## REFUSAL OF PLANNING PERMISSION

APPLICATION NO. 2019/1218

**Proposal** Re-building and extension of existing garage along with erection of a residential annex outbuilding

**At** Gransden House Church Street, Royston, Barnsley, S71 4QZ

DRAWING OF  
PROPOSED, REBUILD OF DETACHED  
GARAGE, ALONG WITH, JOINING, BUILDING  
TO, REAR, PROVIDING, STORE & ANNEX  
PROPOSED, ELEVATIONS

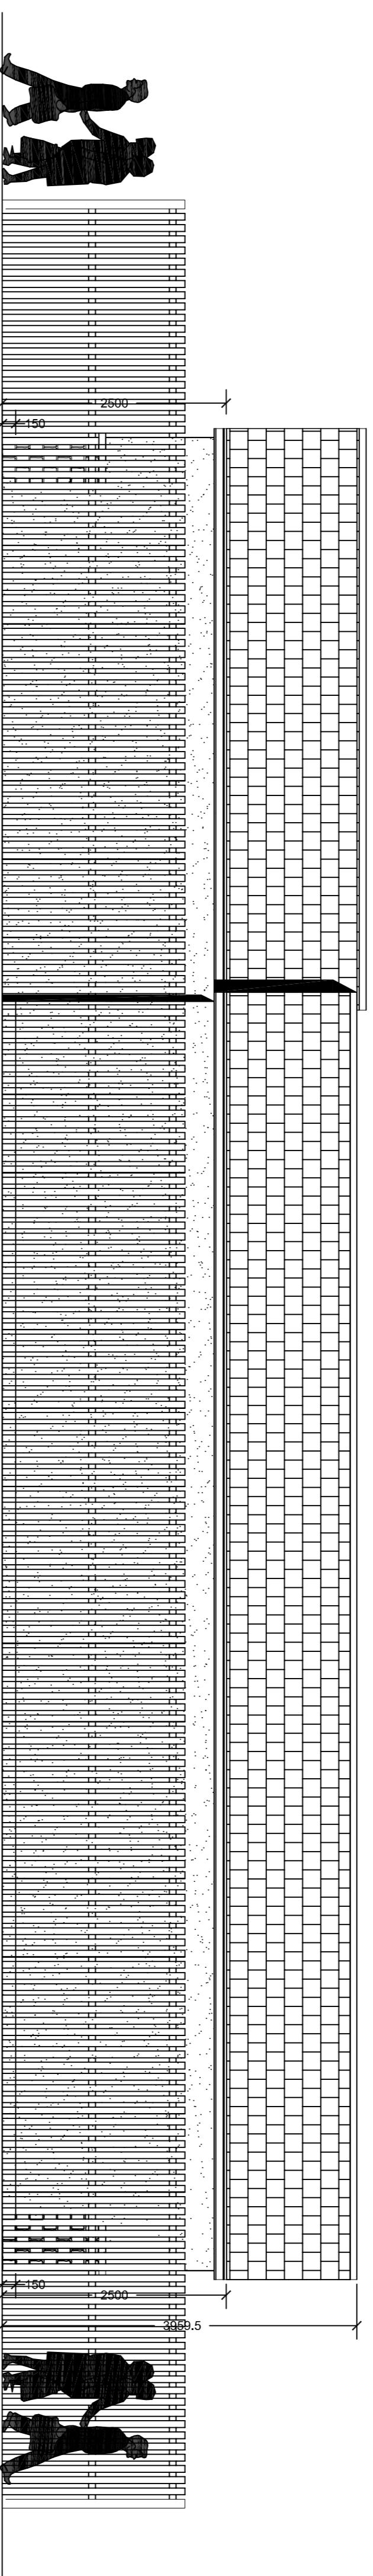
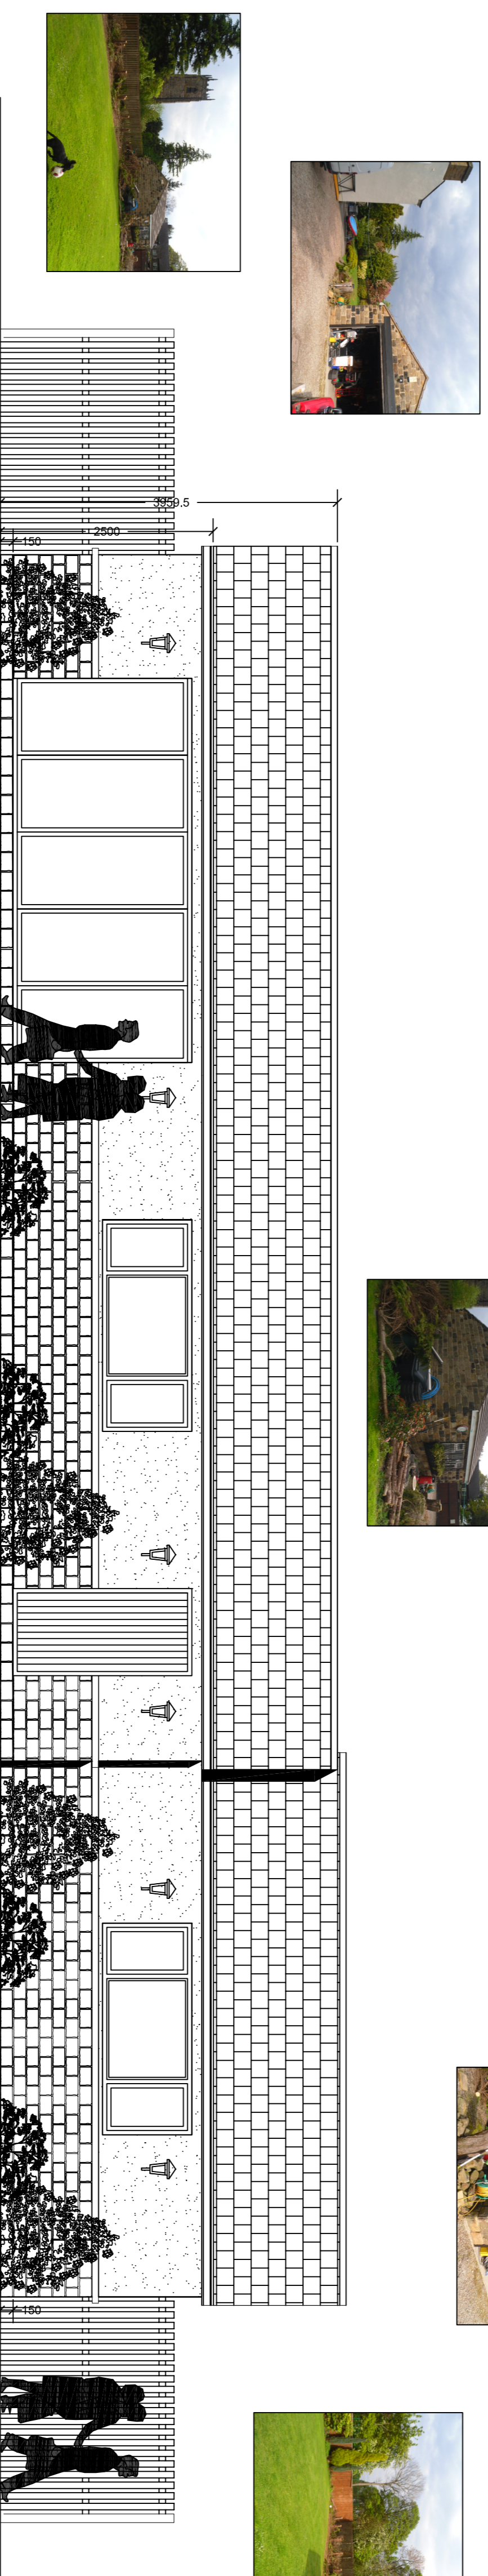
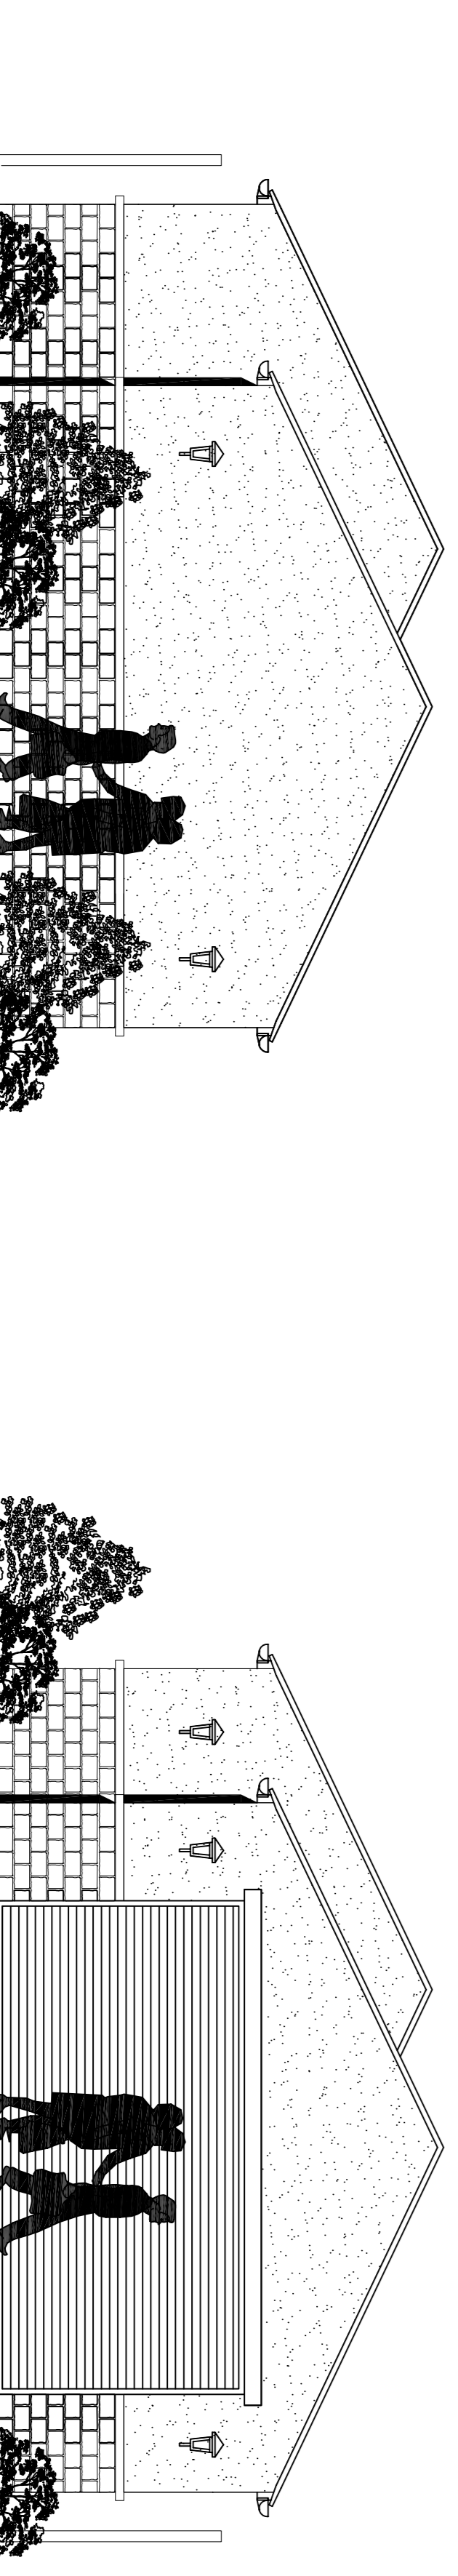
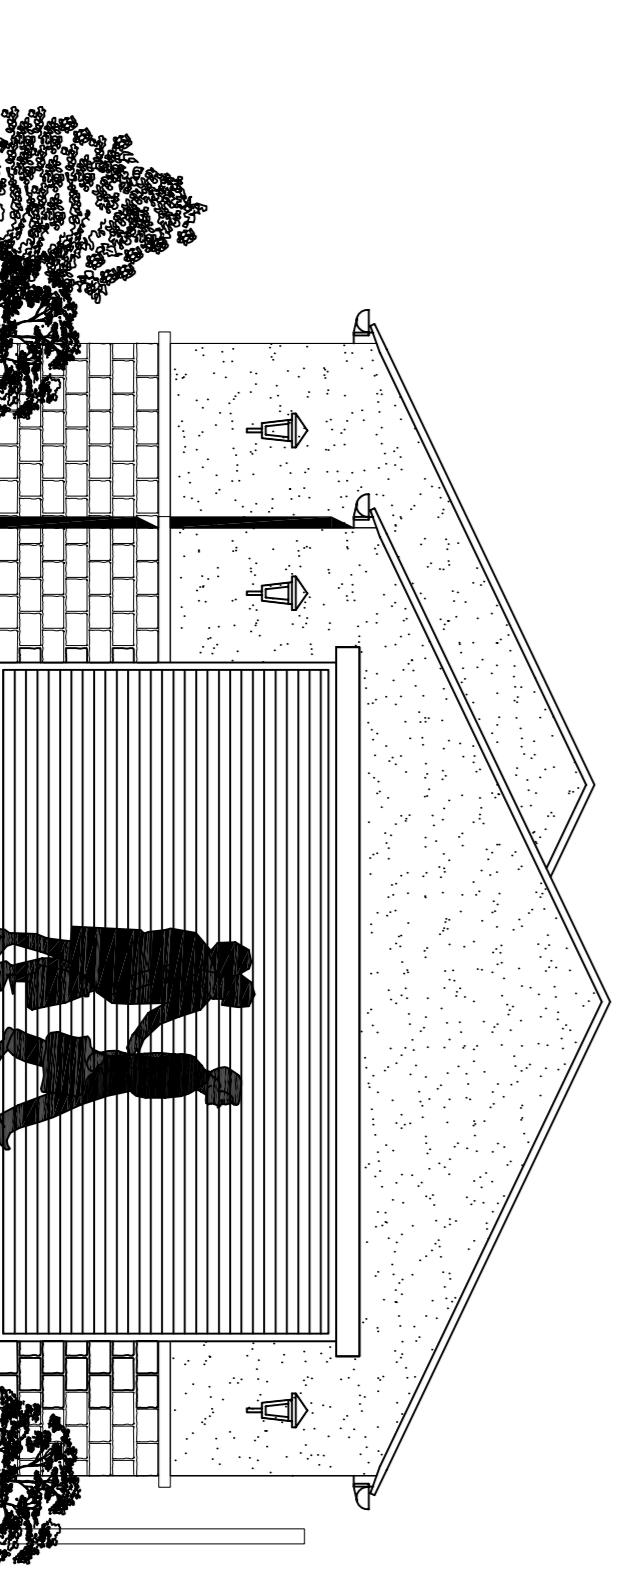
1	In the opinion of the Local Planning Authority the outbuilding proposed would constitute substantial harm to the setting and significance of the Grade I listed Church and its relationship with its former Vicarage (Gransden House) by reason of the proposal's excessive size, its location between the two buildings and its non-vernacular material composition contrary to Local Plan Policies HE1 and HE3 which accord with NPPF Paragraph 193.
2	The proposed development and the harm it causes to the significance of designated and non-designated heritage assets in the vicinity of the proposal, above and below ground including potentially significant archaeological remains, have not been clearly or convincingly justified contrary to the SPD Heritage Impact Assessments as well as Local Plan Policies HE2 and HE6 which accord with NPPF Paragraph 194.
3	It is the view of the Local Planning Authority that the proposal is an unsympathetic and disproportionate addition that detracts from the visual quality of its historic location by reason of its excessive size, irregular footprint and inferior material composition. The proposal is therefore considered to be of a poor design that fails to take the opportunities available for improving the character and quality of its location and the way it functions contrary to Local Plan Policy D1 which is concordant with NPPF Paragraph 130.

4	The development incorporates an annexe use that is capable of functioning as a standalone dwelling due to it containing four rooms which exceed the maximum allowed for annexes set out within the guidance SPD House Extensions and Other Domestic Alterations. The annex is not assessed as a dwellinghouse and does not benefit from other requisite dwellinghouse amenities such as adequate levels of private outdoor amenity space and levels of privacy.

expected of this type of development. The same issues also threaten the amenity and setting of Gransden House as a larger dwellinghouse should the annex be split from the former in the future. The proposal is therefore found to contravene the recommendations set out in the SPD House Extensions as well as the requirements set out in Local Plan Policies GD1 and H9 for the protection of residential amenity and the protection of larger dwellinghouses.
